Arun District Council
Arun Civic Centre
Maltravers Road
Littlehampton
West Sussex BN17 5LF
Planning General Enquiries
Tel: (01903) 737756 Fax: (01903) 730442
Dx: 57406 Littlehampton
Minicom: 01903 732765
e-mail: planning@arun.gov.uk
website: www.arun.gov.uk/planning

Our Ref: BR/315/19/PL
Your Ref:

Development Conversion of the existing first floor office space (B1 Business) into 1 No. two bedroom flat (C3 Dwelling house) including rear access, amenity space & general storage facilities.

Location 98-100 Chichester Road Bognor Regis

SITE LOCATION & BLOCK PLANS

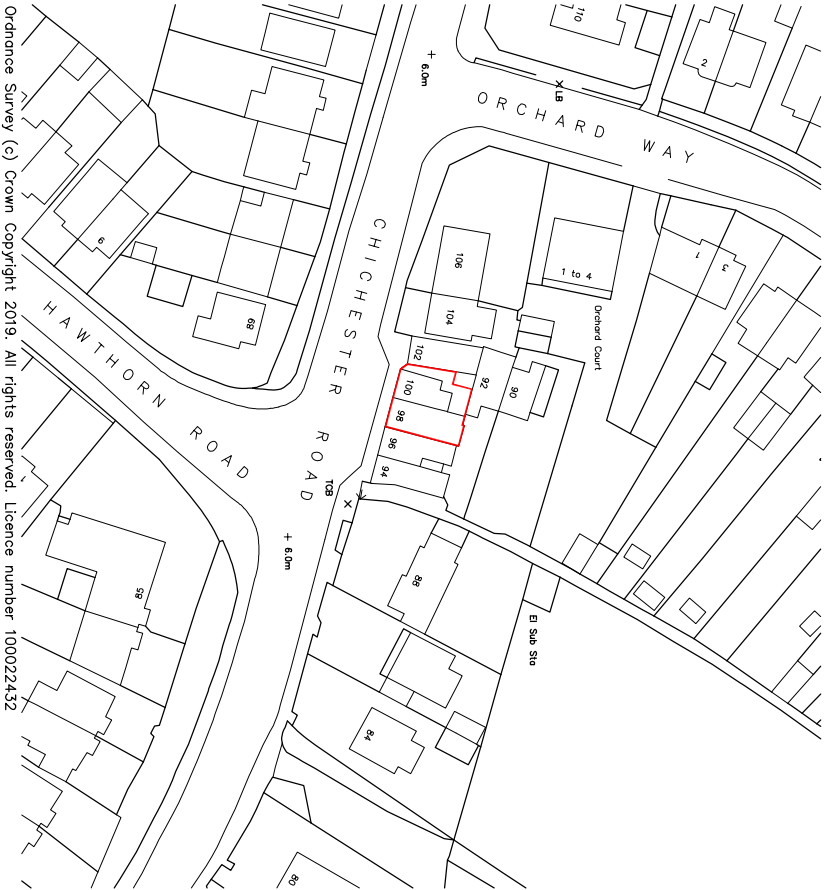
Location Plan

Please submit 1 electronic or 3 paper copies of a location plan at a scale of 1:1250 or 1:2500 for rural areas. Further details of what must be included on the plan can be found in the National Validation Requirements.

On the proposed site plan, please clearly indicate the position of the new/altered vehicle access as annotated on the application form.

On the proposed site plan, please show the position of the proposed lights on the rear section of path and entrance gates.
